From: Laura Gibbons
Sent: 13 September 2018 14:28
To: Planning.Responses
Subject: RE: Planning Consultation on P/83/18/DOC

Engineers Comments Regarding Condition 4- Surface Water Drainage

APPLICATION NO: P/83/18/DOC

Site Address: Land at former Kings Beach Hotel The Parade Pagham PO21 4TW

SOAKAWAY TEST RESULTS & SOILS INFILTRATION RATE

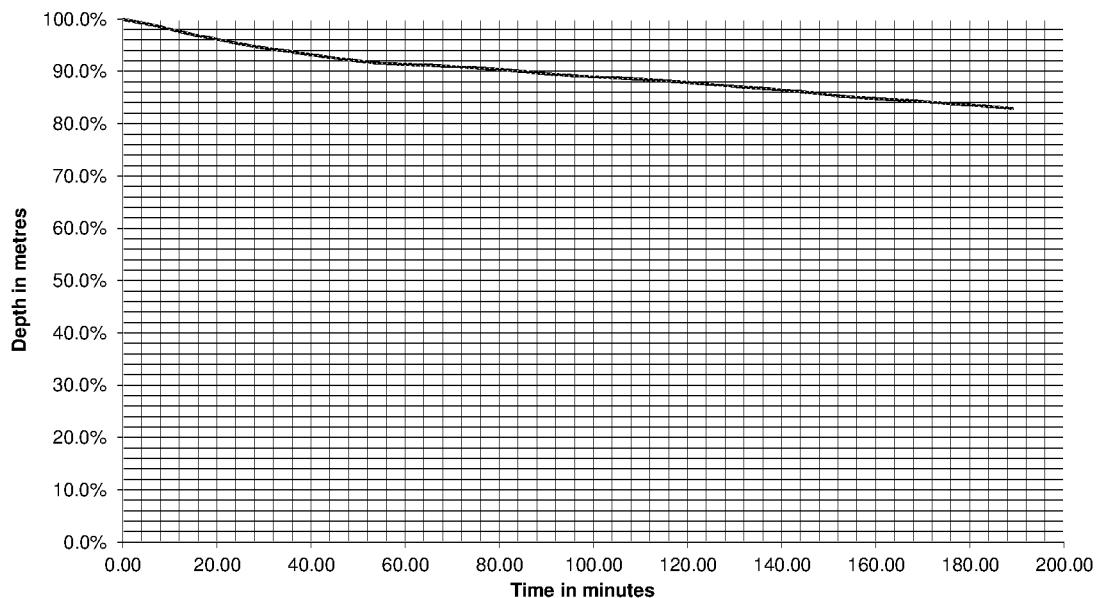
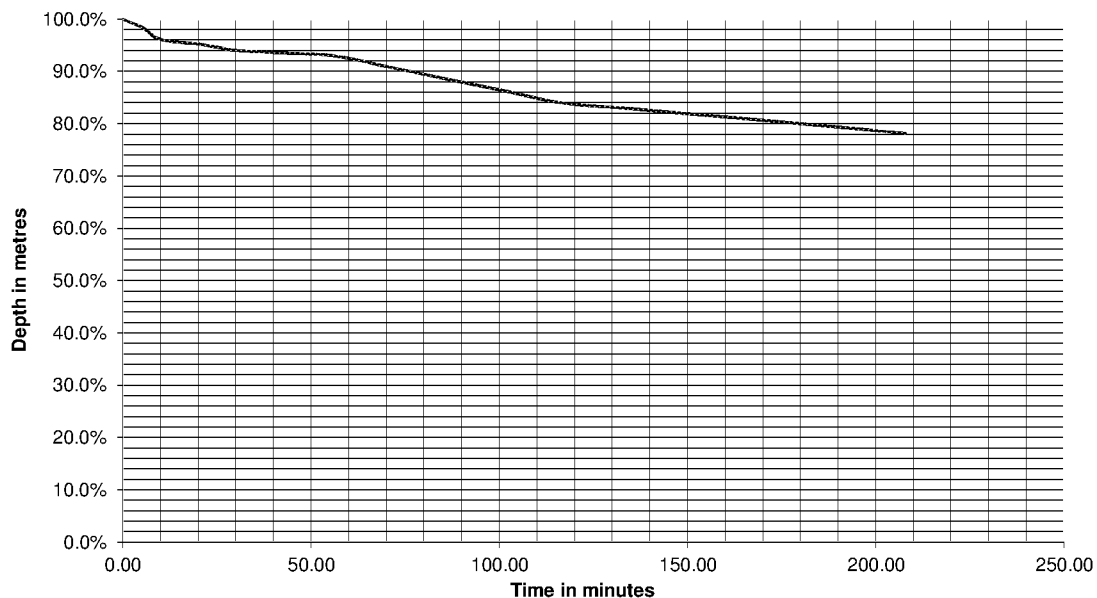
Groundwater monitoring results and infiltration testing results were provided. Maximum recorded groundwater levels were found to be m. Infiltration rates provided were low, $\times 10^{-6}$, however the percolation tests were completed at 2m depth, i.e. into the groundwater which was recorded as being at 1.35 mbgl.

The overlying strata are also of a more suitable type for infiltration. Shallow infiltration tests need to be completed at 600mm depth.
